Sheringham Shoal and Dudgeon Offshore Wind Farm Extension Projects

Explanatory Note to Updated Offshore Works Plans

January 2023
Document Reference: 2.7.1
APFP Regulation:

Title:	
Sheringham Shoal and Dudgeon Offshore Wind Farm Extension Projects Examination submission	
Explanatory Note to Updated Offshore Works Plans	
PINS document no.: 2.7.1	
Document no.: C282-EQ-Z-GA-00023	
Revision: A	
Date:	Classification
5 January 2023	Final
Prepared by:	
Equinor	
Approved by:	Date:
Sarah Chandler, Equinor	5 January 2023

Offshore Works Plans (without prejudice) – all
scenarios

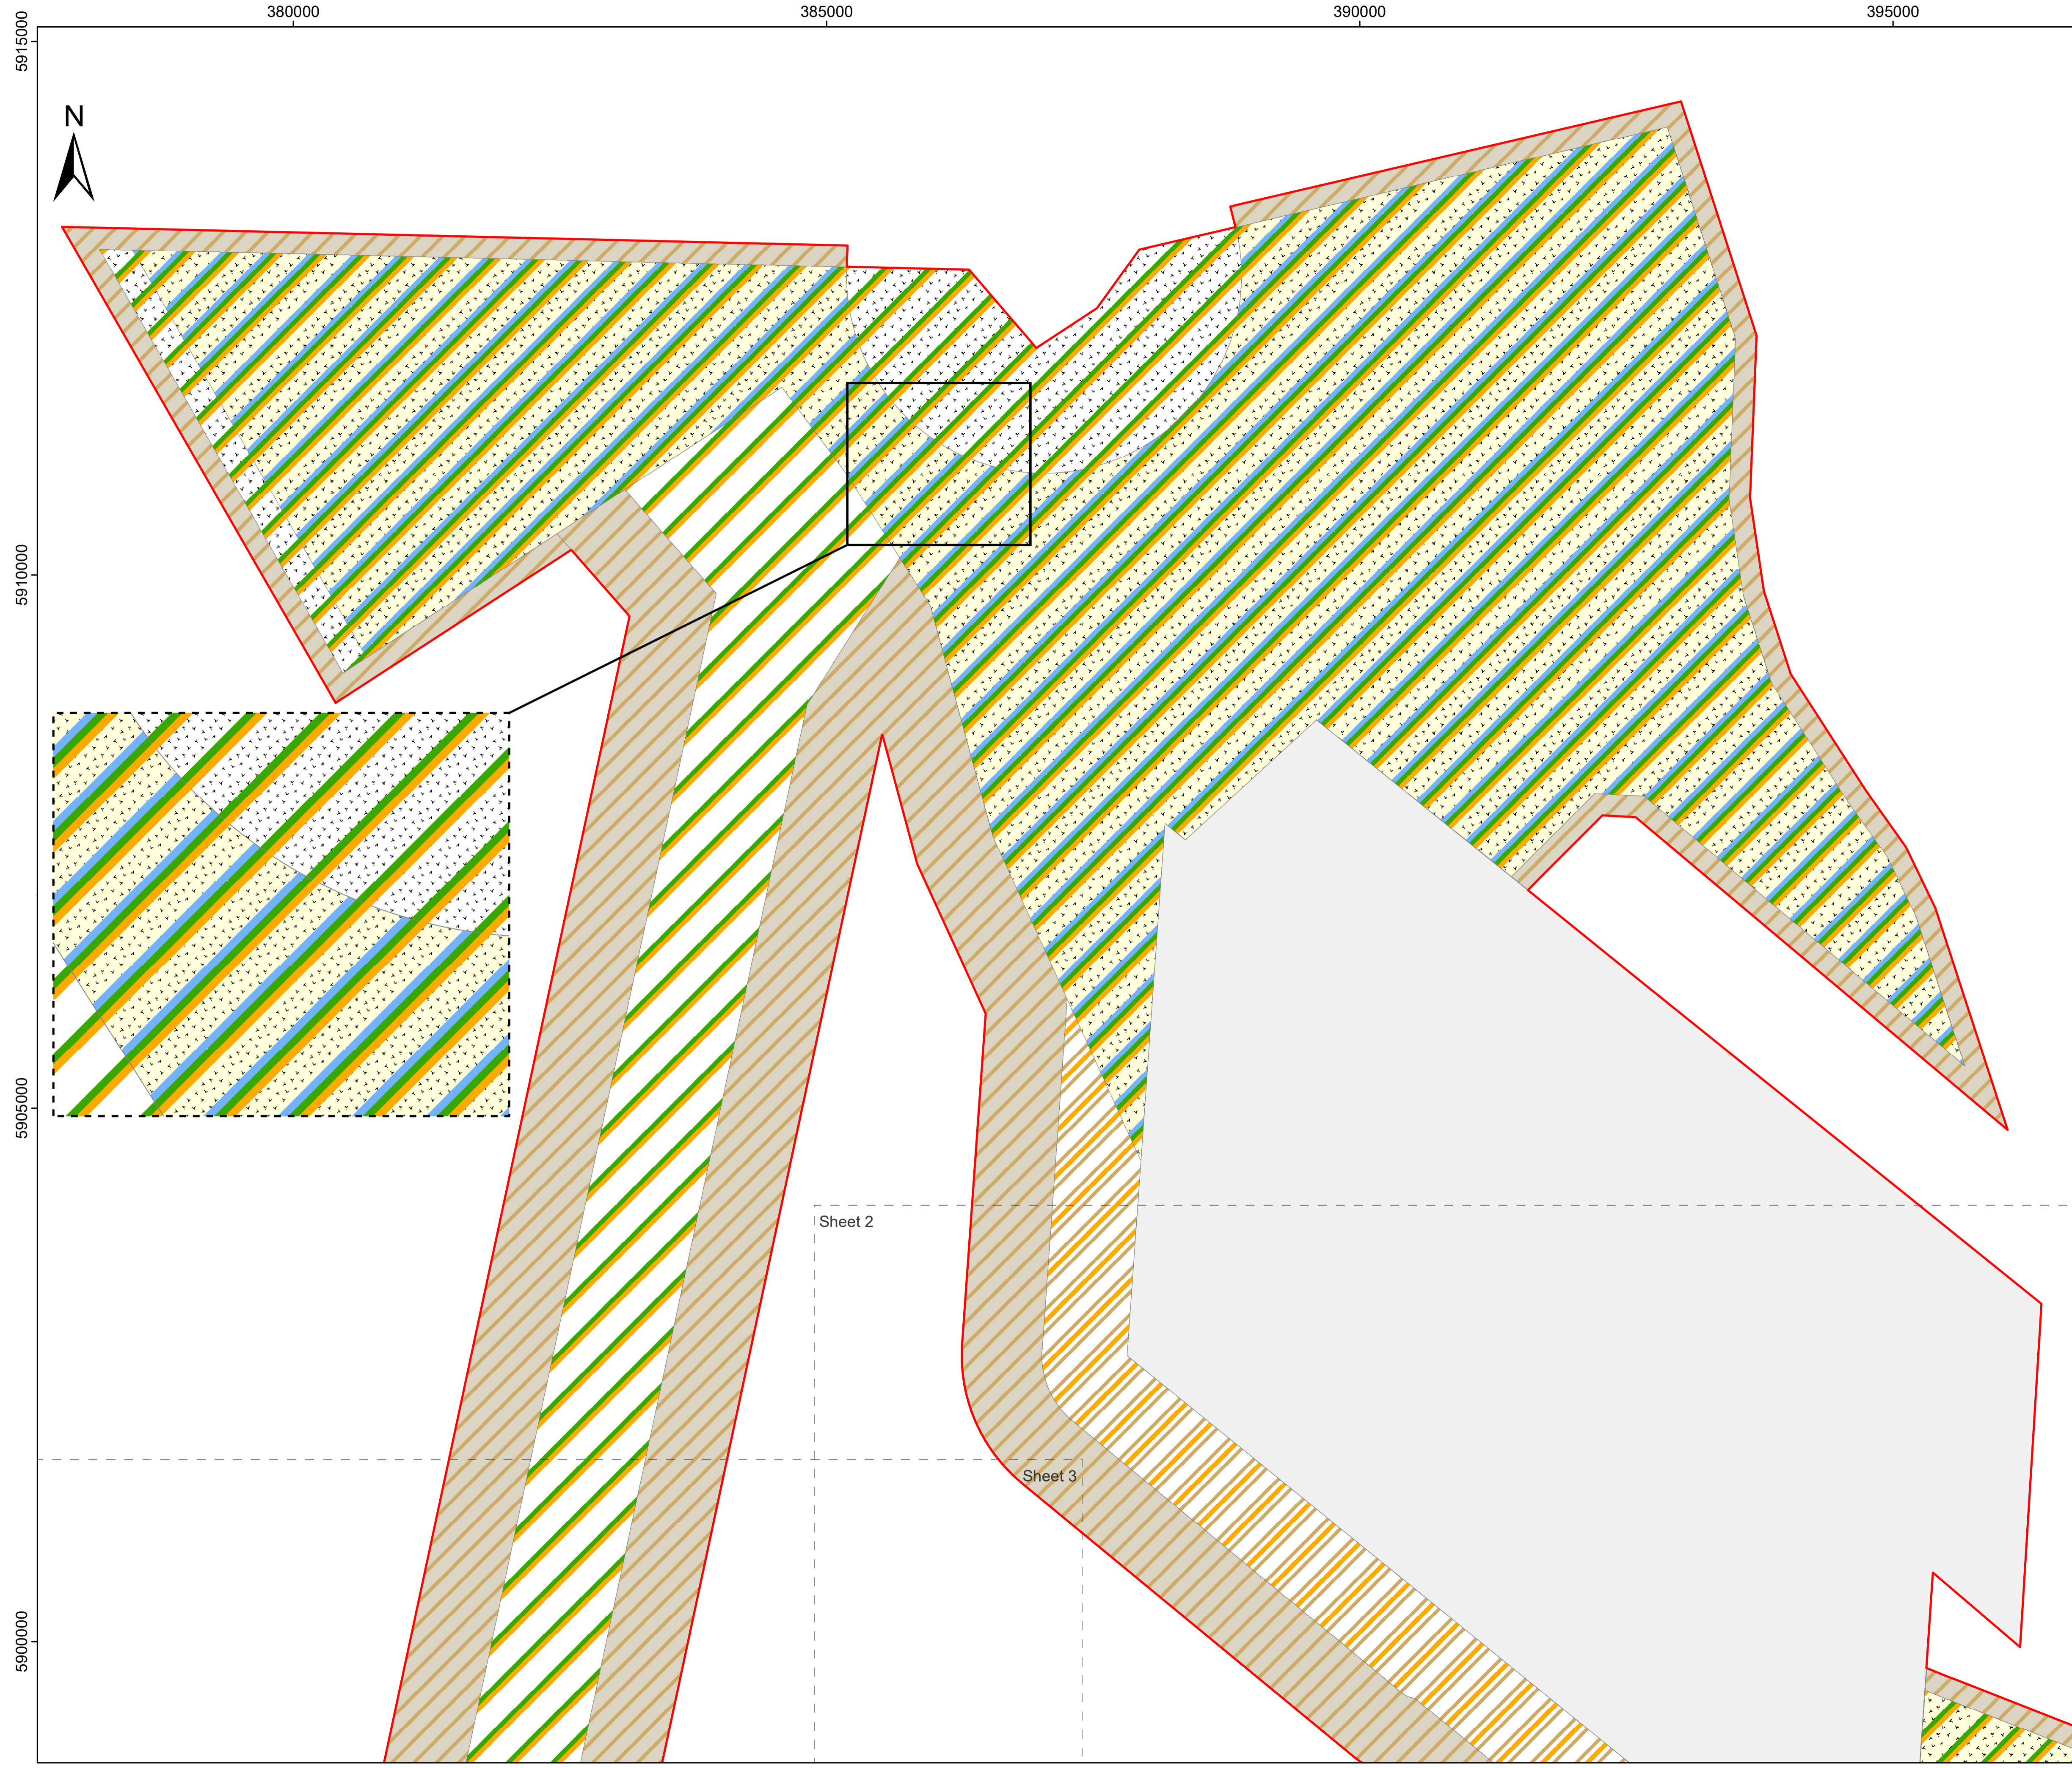
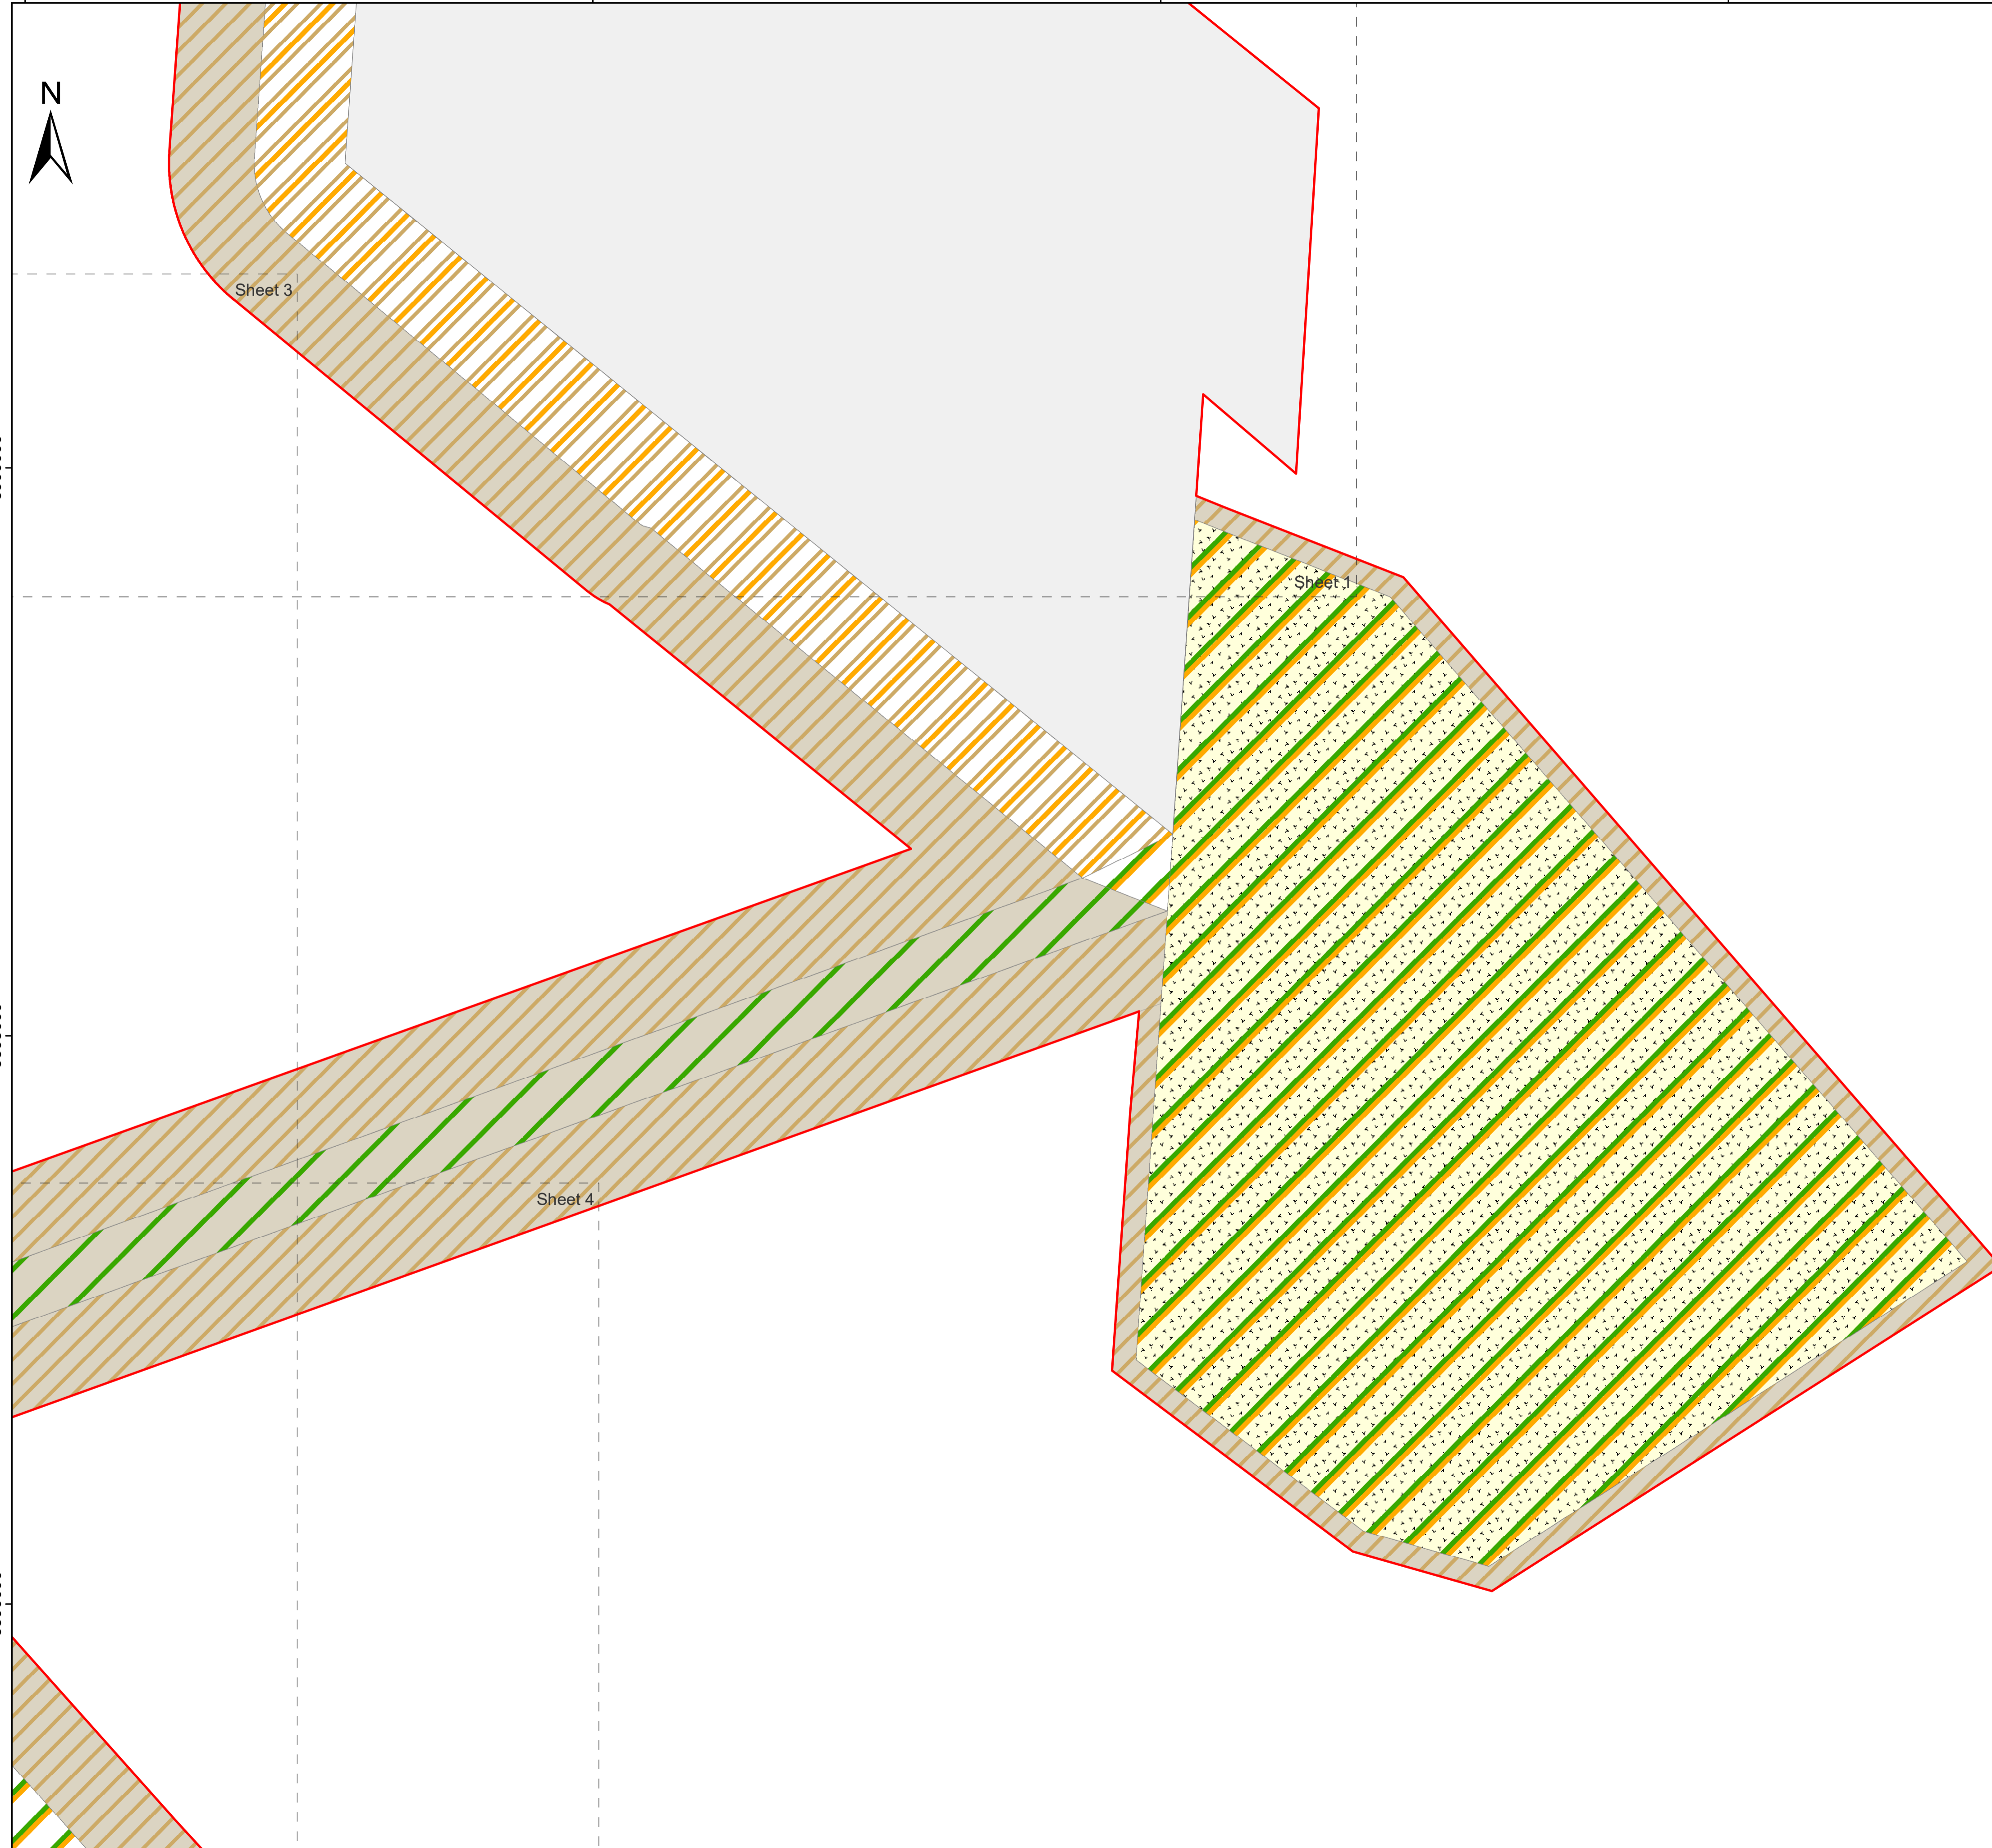
- Work No. 4B and 4C (export and interlink cables) have been included in the DEP North and DEP South array areas, where previously they were limited to the cable corridors only.

- The presentation of Work No. 6C (temporary working area) on the scenario 4 plans has been changed to be consistent with that used on the "all scenarios" plans.
